**WELWYN HATFIELD BOROUGH COUNCIL
EXECUTIVE DIRECTOR - PLANNING, PUBLIC PROTECTION AND GOVERNANCE**

Application No: 6/2021/2994/ADV
Location: 17-19 Howardsgate Welwyn Garden City AL8 6AL
Proposal: Installation of 1 x internally illuminated sign, 1 x internally illuminated fascia sign, 1 x externally illuminated sign, and 1 x externally illuminated hanging sign (retrospective).
Officer: Mrs Sarah Madyausiku

6/2021/2994/ADV

HOWARDSGATE ELEVATION - 1:50@A1, 1:100@A3

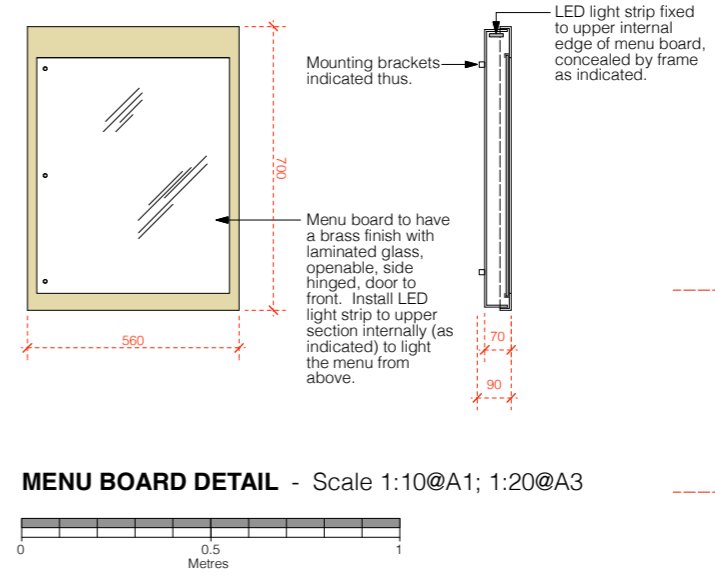
There are no objections to the fascia sign or hanging sign on Howardsgate. The application has been assessed by the Conservation Officer, who considers that the "board" sign on the north elevation (fronting Wigmores North) is not sympathetic to the building or the appearance of the Conservation Area due to its size, illumination and position low on the elevation.

WIGMORES NORTH ELEVATION - 1:50@A1, 1:100@A3

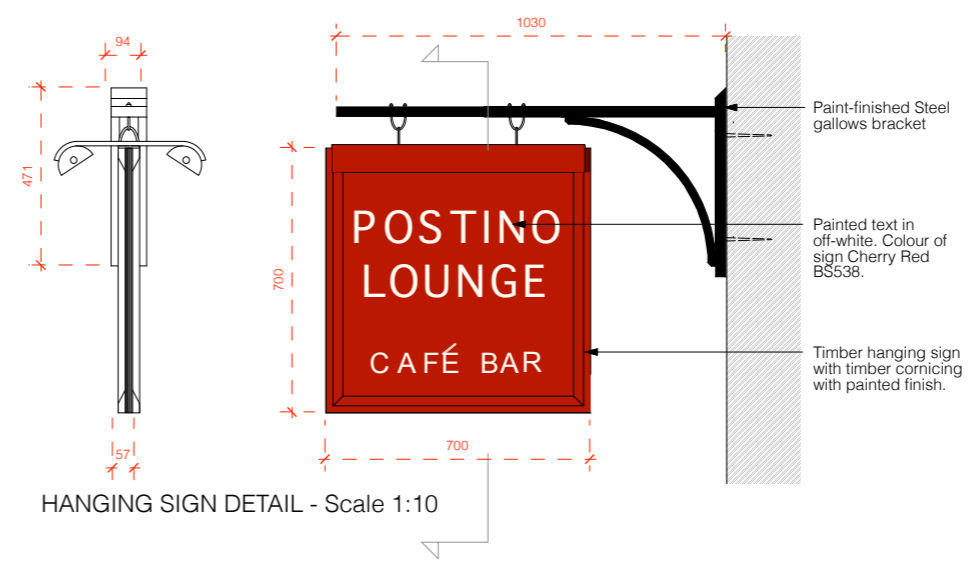
With regard to this externally illuminated "board sign" it is located at ground floor level on the north elevation (fronting Wigmores North). It is made of timber and is illuminated from above by 3 swan neck lights. The design and method of illumination of the sign is not at odds with the more bland elevation of this section of the building. The sign neither attracts nor detracts from its surroundings. It has a neutral impact on the character and appearance of this application site and this part of the Welwyn Garden City Conservation Area and is, on balance, acceptable in terms of its impact upon amenity and the character of the area.
